**PLANNING REF: LU/116/21/PL – Land South Of The Littlehampton
Academy Fitzalan Road Littlehampton BN17 6ED**

**PRE-APPLICATION RESPONSE - HOUSING STRATEGY AND ENABLING MANAGER
ARUN DISTRICT COUNCIL**

ANNEX 1
AFFORDABLE HOUSING PLAN

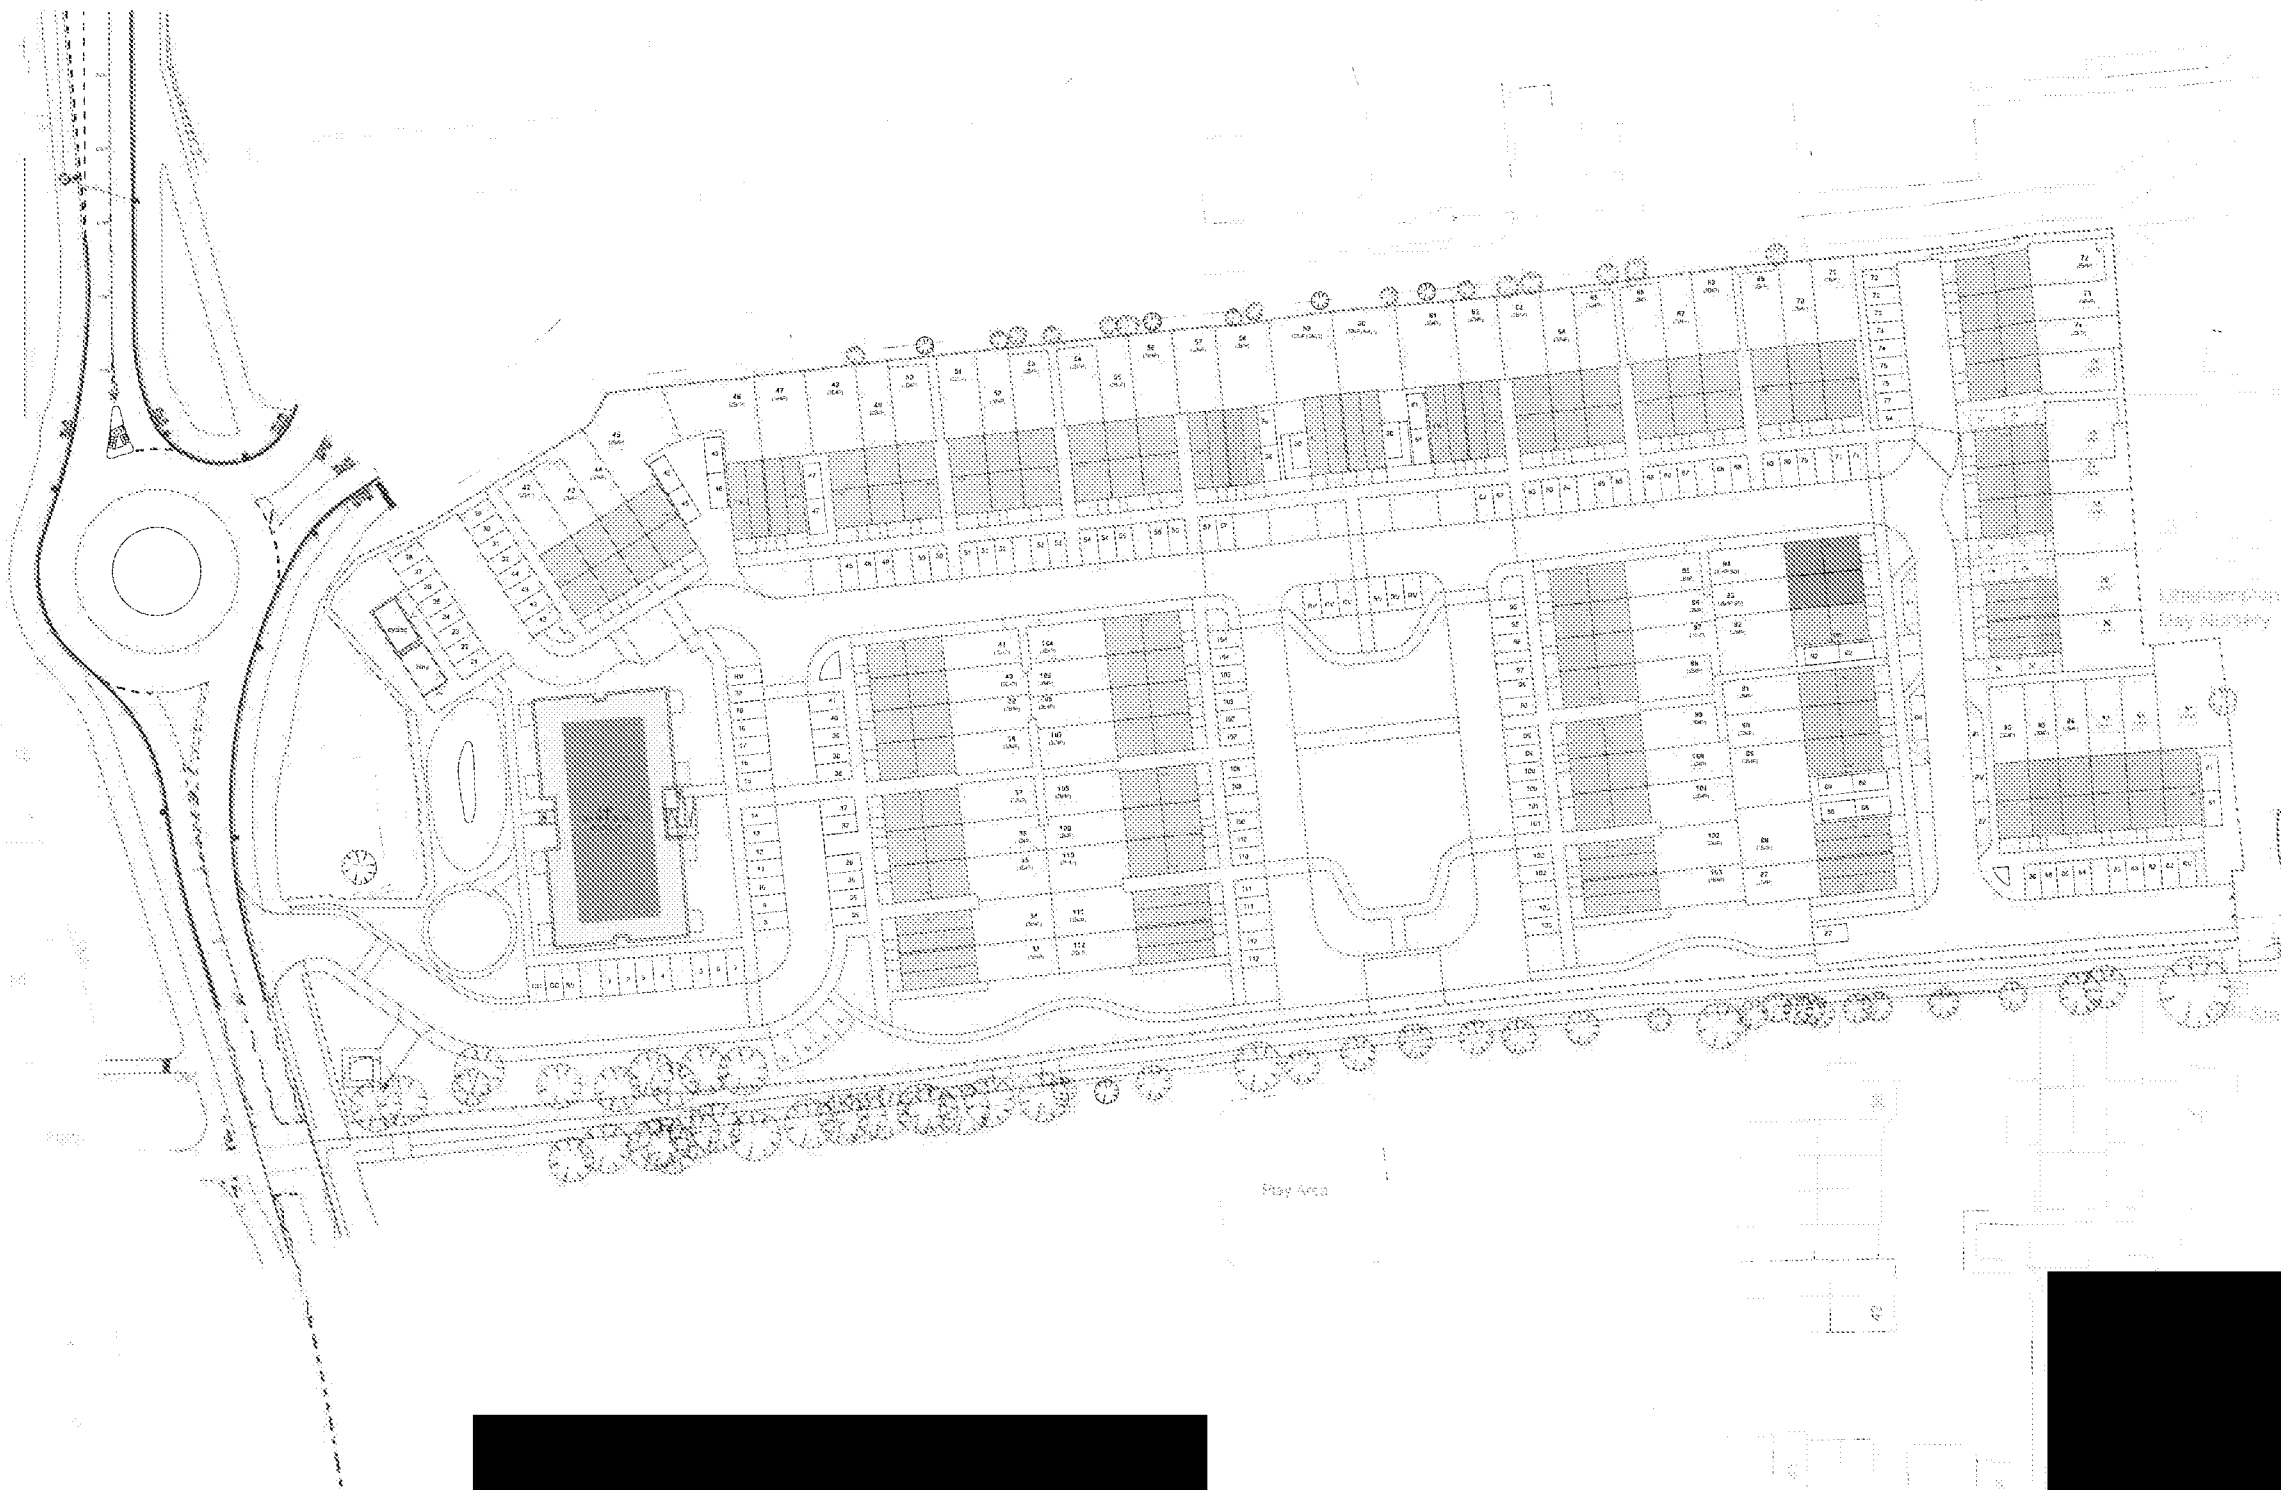
The proposed development should comply with Policy AH SP2 of the Local Plan in terms of clustering. The affordable dwellings should be in small clusters, of no more than five dwellings, which are pepper potted throughout the development and should be indistinguishable in design from the market housing.

Furthermore, the scheme does not accord with Policy AH SP2 of the Local Plan in terms of clustering as all but two of the affordable housing units are located in one part of the site.
